CITY OF ALBUQUERQUE

Re: Event Hall
900 Old Coors Dr. SW
Traffic Circulation Layout
Architect's Stamp 05-05-23 (L11-D070)

Based upon the information provided in your submittal received 05-23-23, the above referenced plan cannot be approved for Building Permit until the following comments are addressed:

1 TCL - Site Plan
1" = 20'-0"

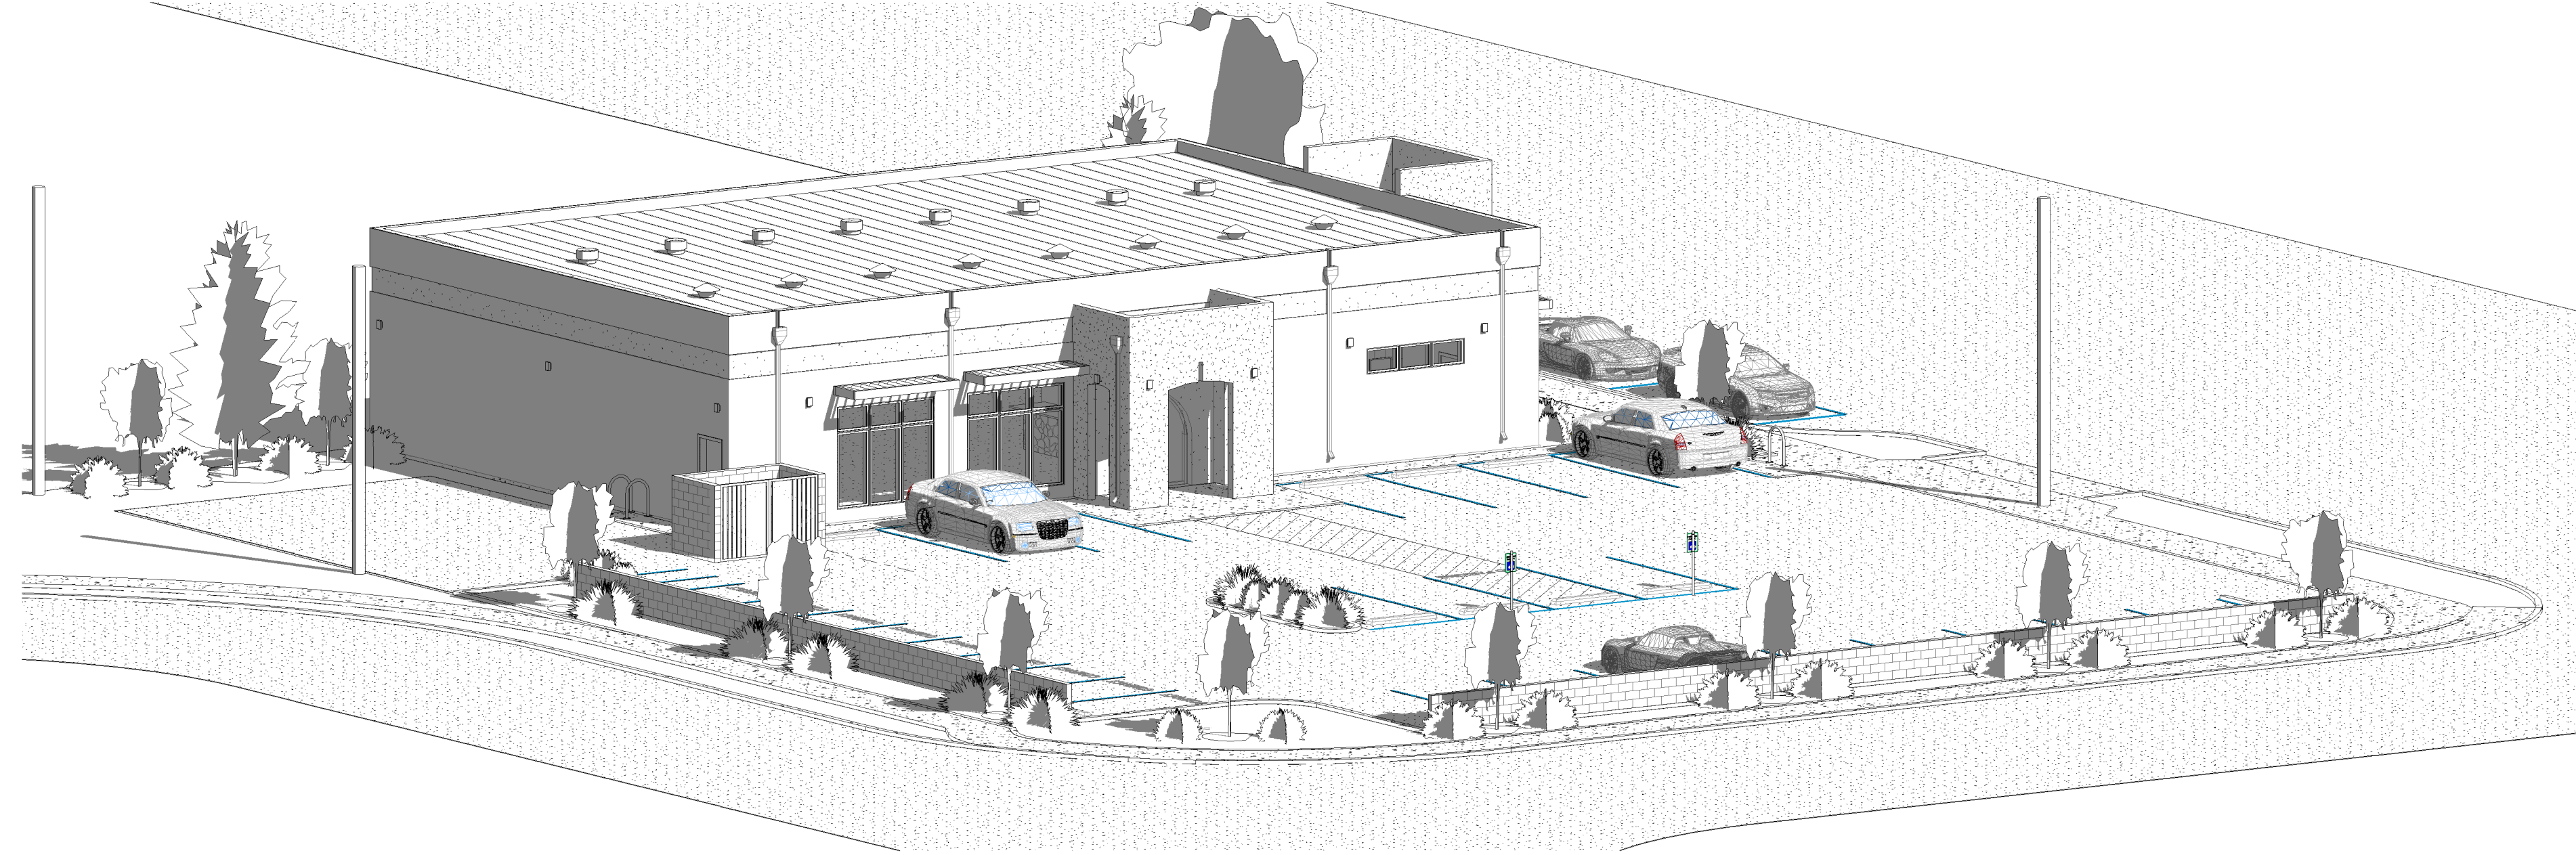
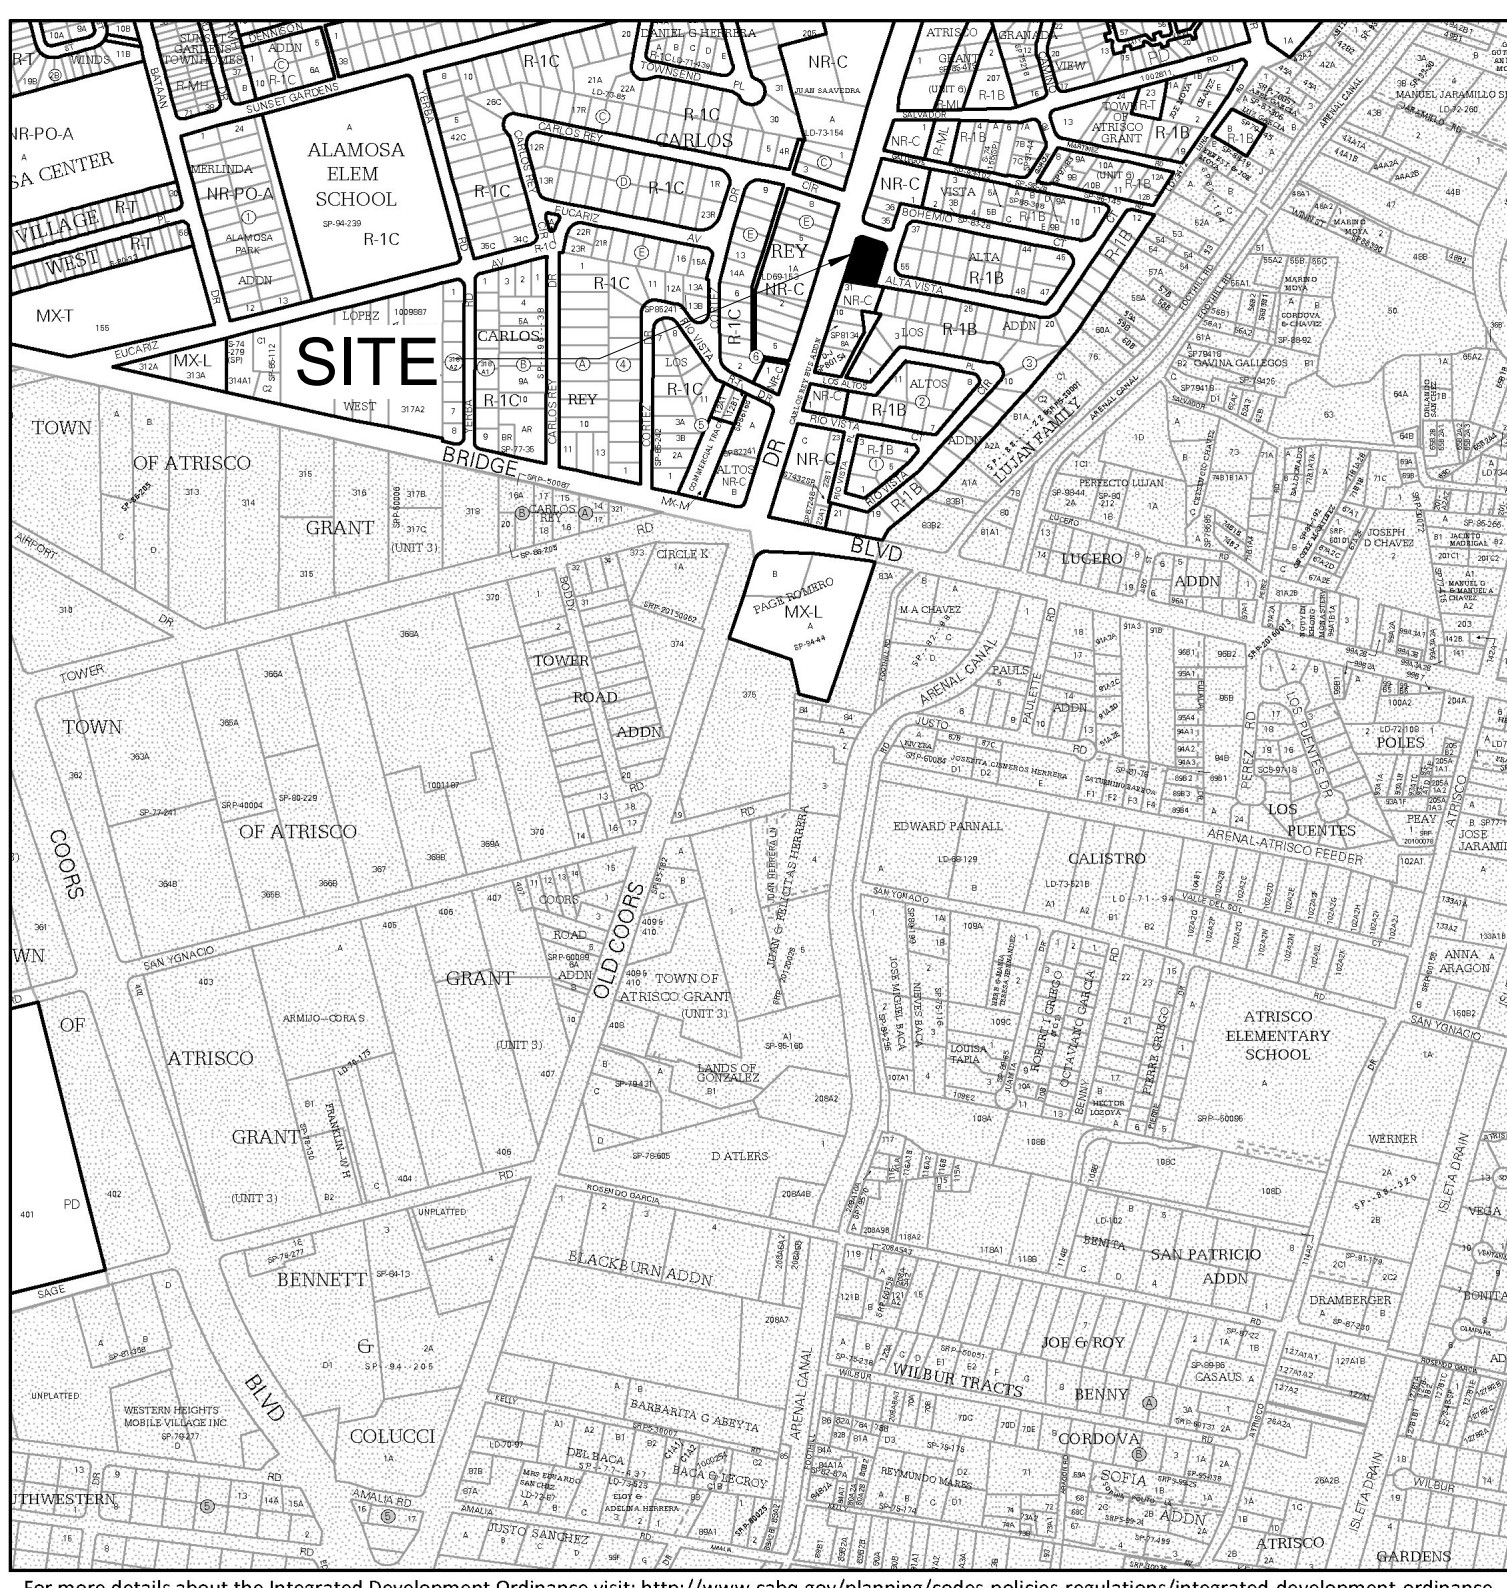
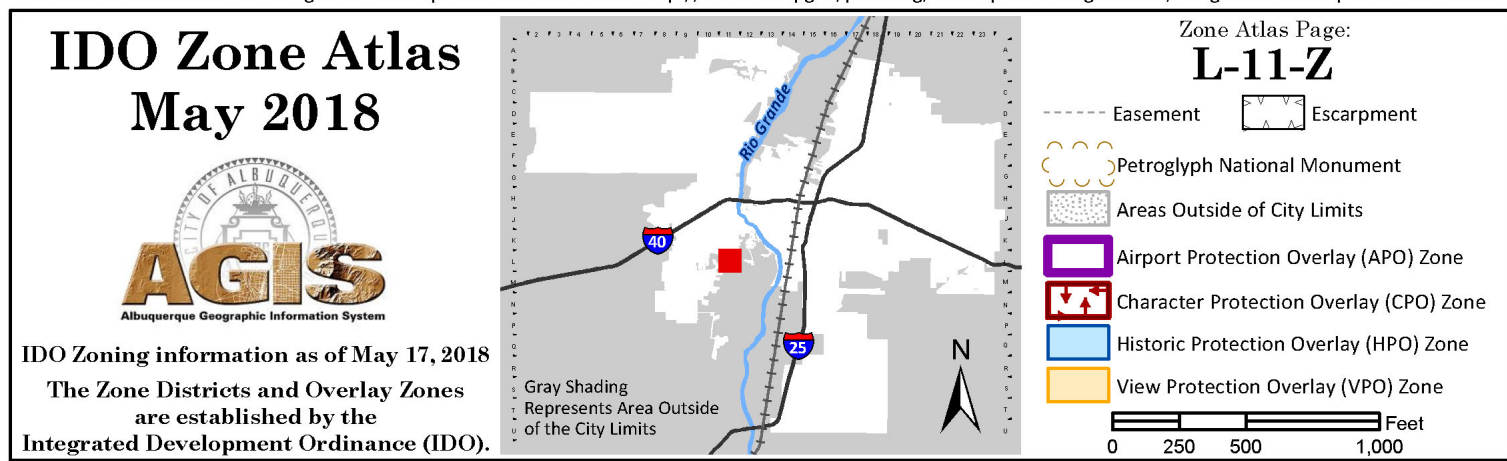
1. List the number of Bicycle parking spaces required by the IDO.
2. Identify all existing access easements and rights of way width dimensions.
3. Identify the right of way width, medians, curb cuts, and street widths on Old Coors Dr. and Alta Vista Ct.
4. The minimum distance from the site access to the intersection is 100 ft. so, the north side site access must be closed and replaced with sidewalk and curb & gutter. A build note must be provided referring to the appropriate City Standard drawing 2430.

5. South side site access must be a minimum 22 ft. wide to serve two-way traffic.
6. A minimum 4-foot wide pedestrian path should be shown around the pole; show this dimension on the site plan to ensure that a minimum 4-foot wide path is obtained.

7. Please clarify, is this ADA pathway flush or an ADA ramp will be provided?

8. Per the IDO, a 6 ft. wide ADA accessible pedestrian pathway is required from the public sidewalk to the building entrances. Please clearly show this pathway and provide details.

9. Refuse vehicle maneuvering shall be contained on-site. The refuse vehicle shall not back into the public right of way.; provide a copy of refuse approval.

10. Provide a copy of Fire Marshall approval.
11. Show the clear sight triangle and add the following note to the plan: "Landscaping and signage will not interfere with clear sight requirements. Therefore, signs, walls, trees, and shrubbery between 3 and 8 feet tall (as measured from the gutter pan) will not be acceptable in the clear sight triangle.

12. Please specify the City Standard Drawing Number when applicable.
13. Add a note stating "All broken or cracked sidewalk must be replaced with sidewalk and curb & gutter." A build note must be provided referring to the appropriate City Standard drawing.
